Re: Review letter for West Magnolia (FKA East Sunnyside) PRD/BSP (PA22-033)

Dear Kathryn,
Thank you for your review letter dated August 28, 2024. Attached is a copy of the letter and comments with responses to all of the departments comments. In addition to the responses, please see the new client comments on sheet 9.

PROJ. NO. 24027 SHEET 3 OF 4

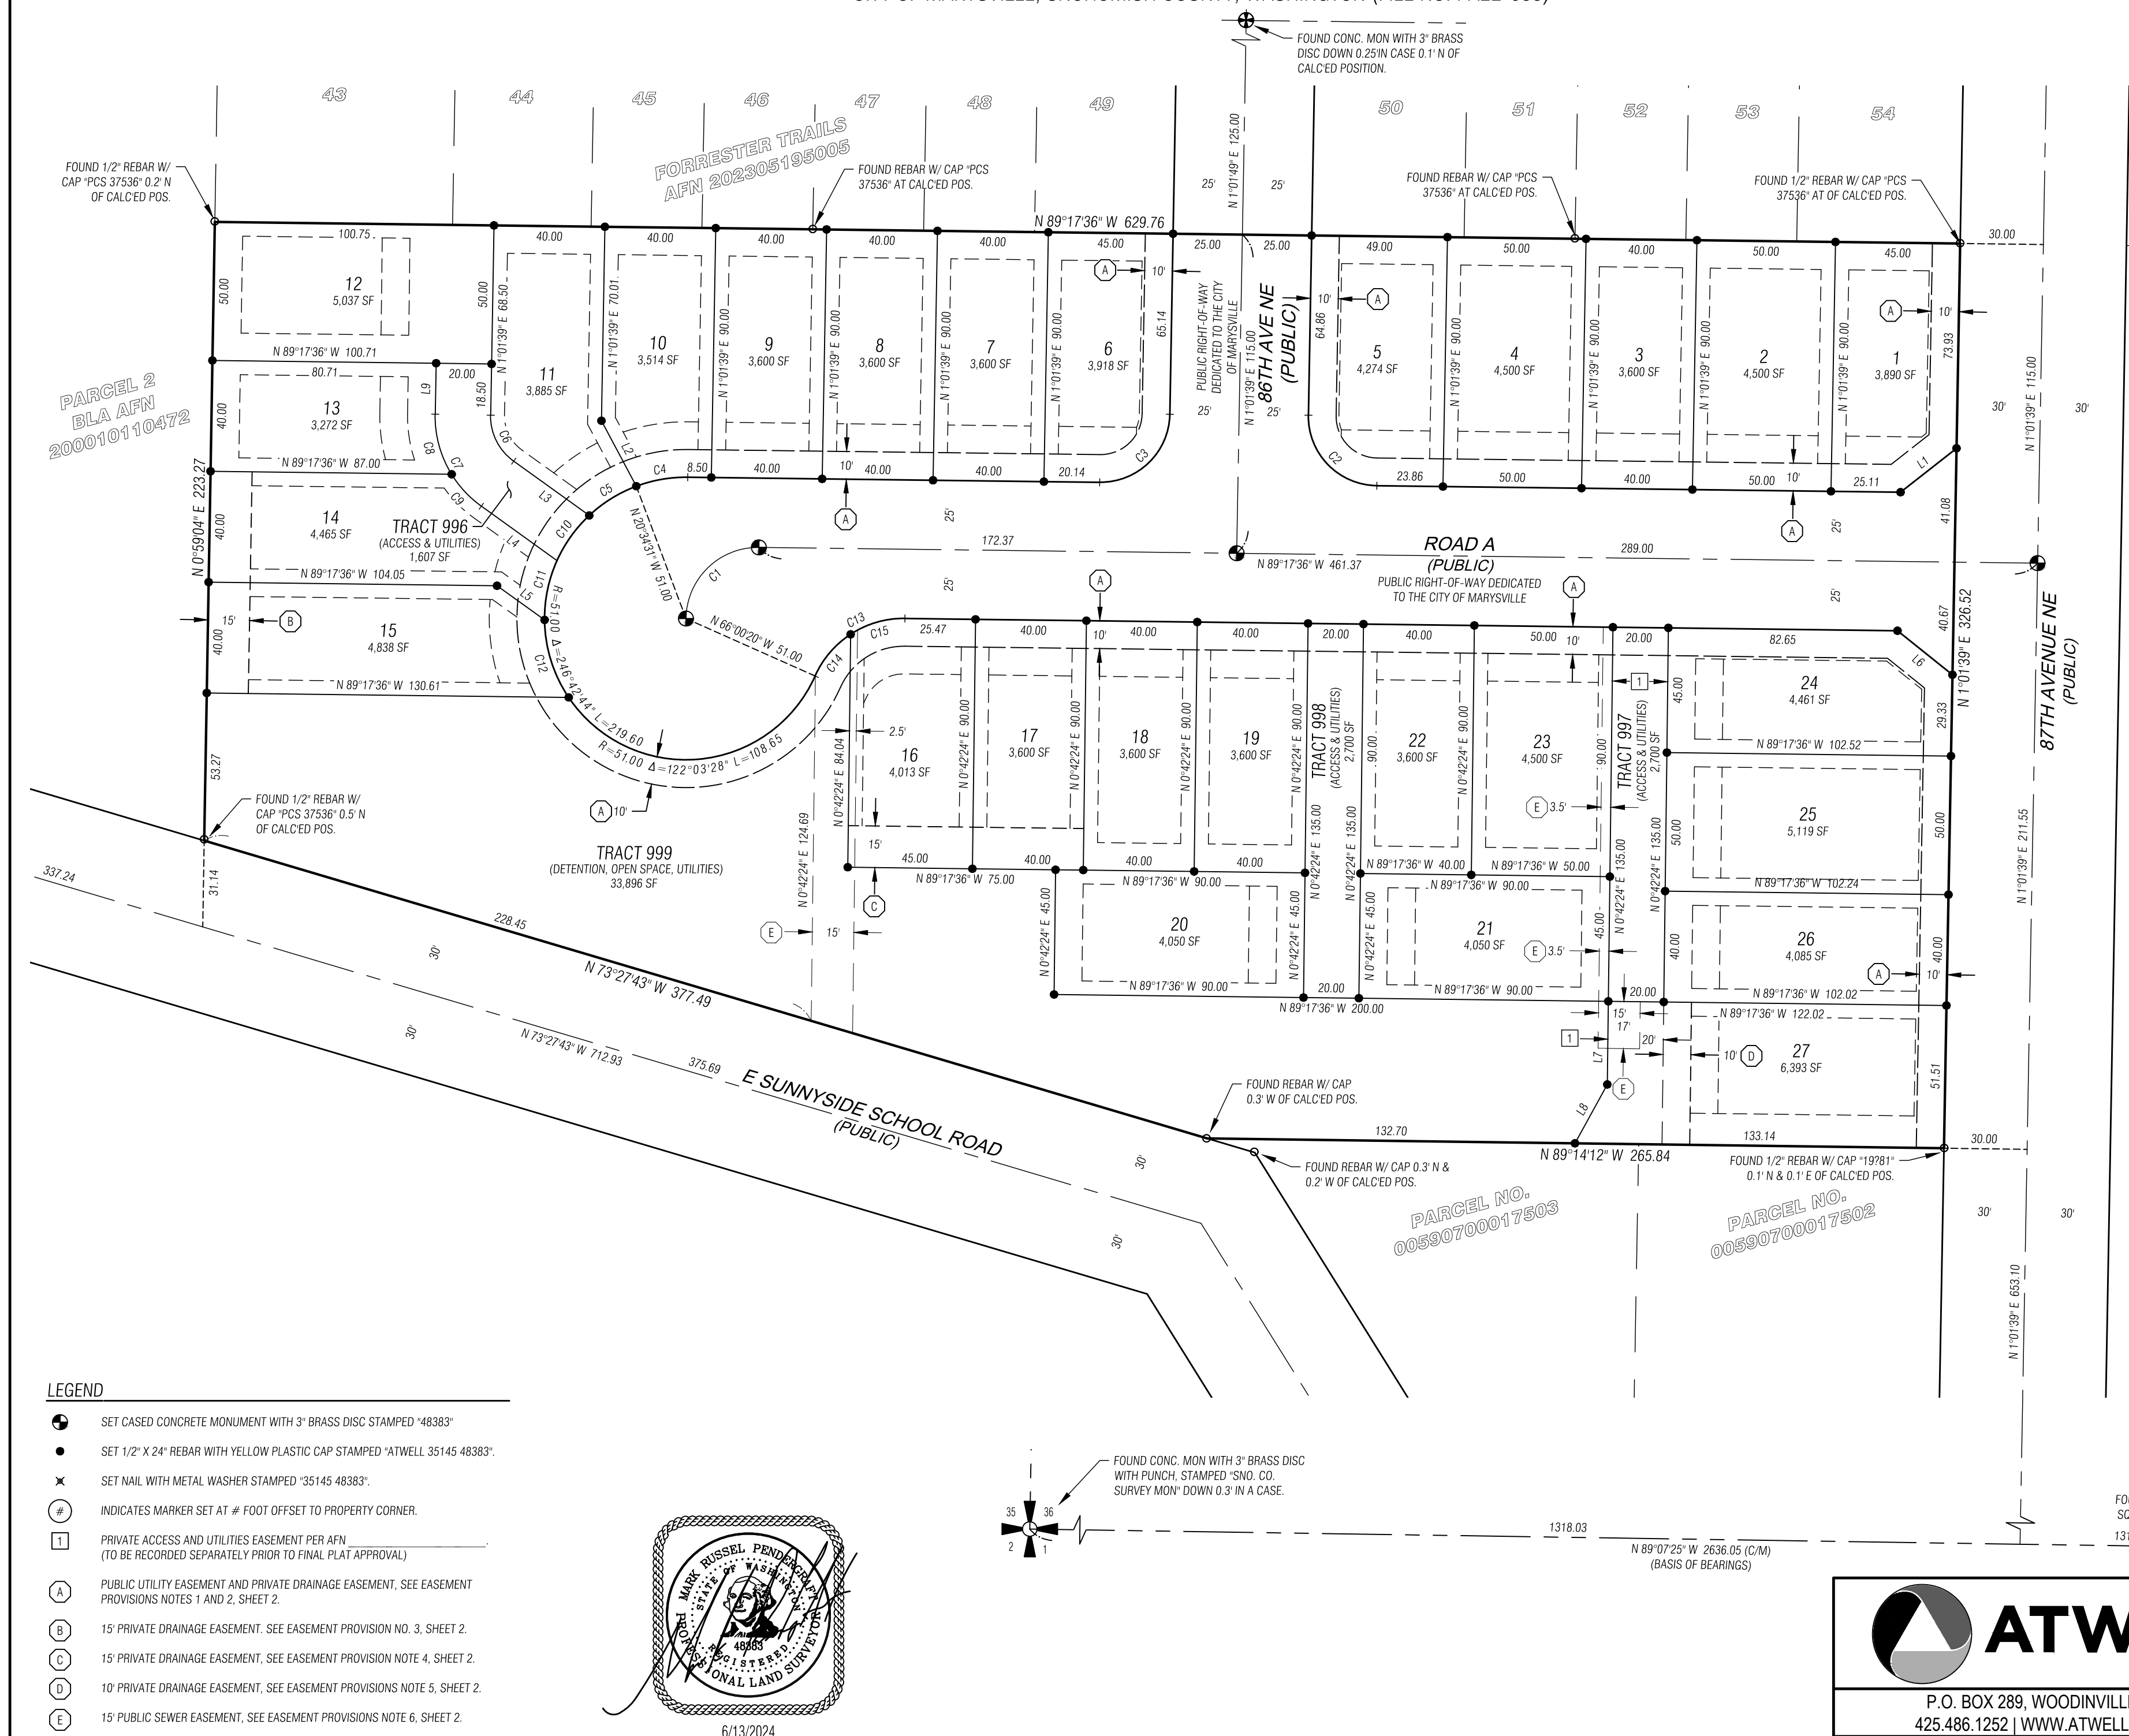
iii. Depict Snohomish PUD easement and reference AFN#202401100143

Shown on sheets 3 and 4
